NC DEPARTMENT OF  
**HEALTH AND  
HUMAN SERVICES**

October 3rd, 2023

RE: Food Lion #2607  
1243 East Cumberland Street  
Dunn, NC 28334

This letter acknowledges review of the remodel plan for the above referenced establishment. The plans received on 07/12/2023 application, and specifications including email correspondence are approved with the following comments:

1 WATER PIPING PLAN
P1.03 / SCALE: 3/32" = 1'-0"
NORTH

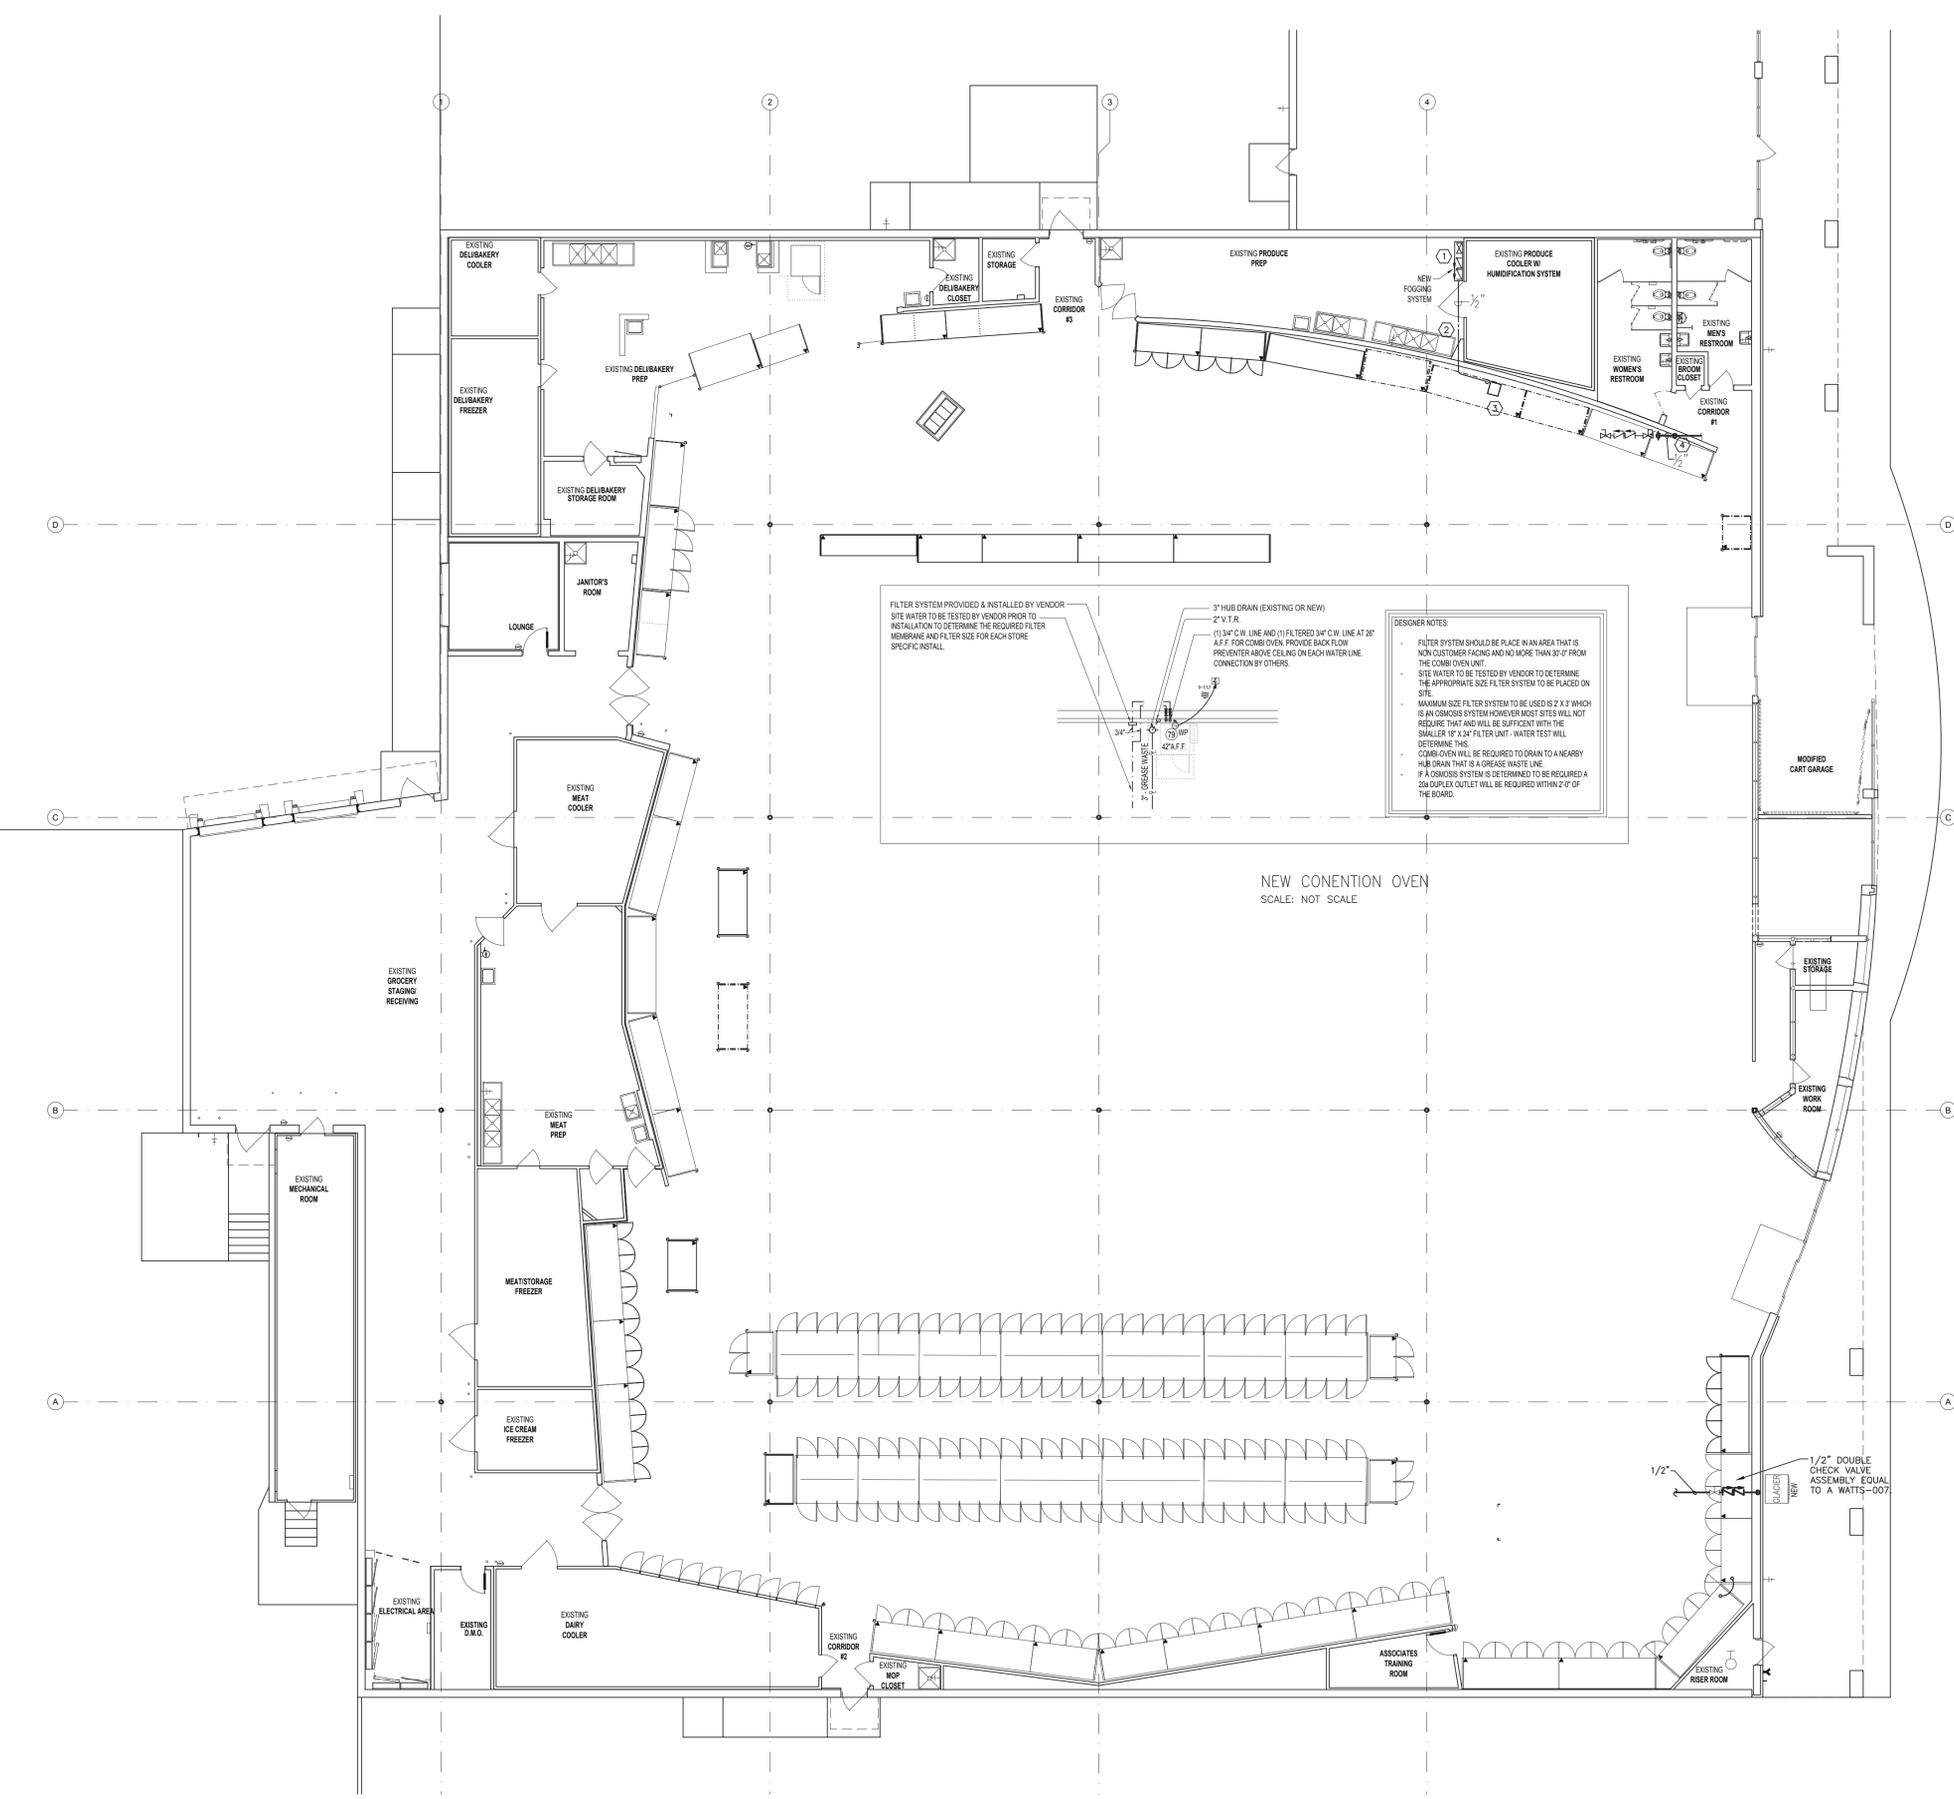
4. The existing Sanitary Sewer and Water Piping plans are approved for continuous use. The hot water heating system supplied as specified is also approved for continuous use. The existing water heating system is acceptable if it is sufficient to meet peak hot water demands. If it does not, the hot water system will be modified, and/or replaced to meet hot water requirements.
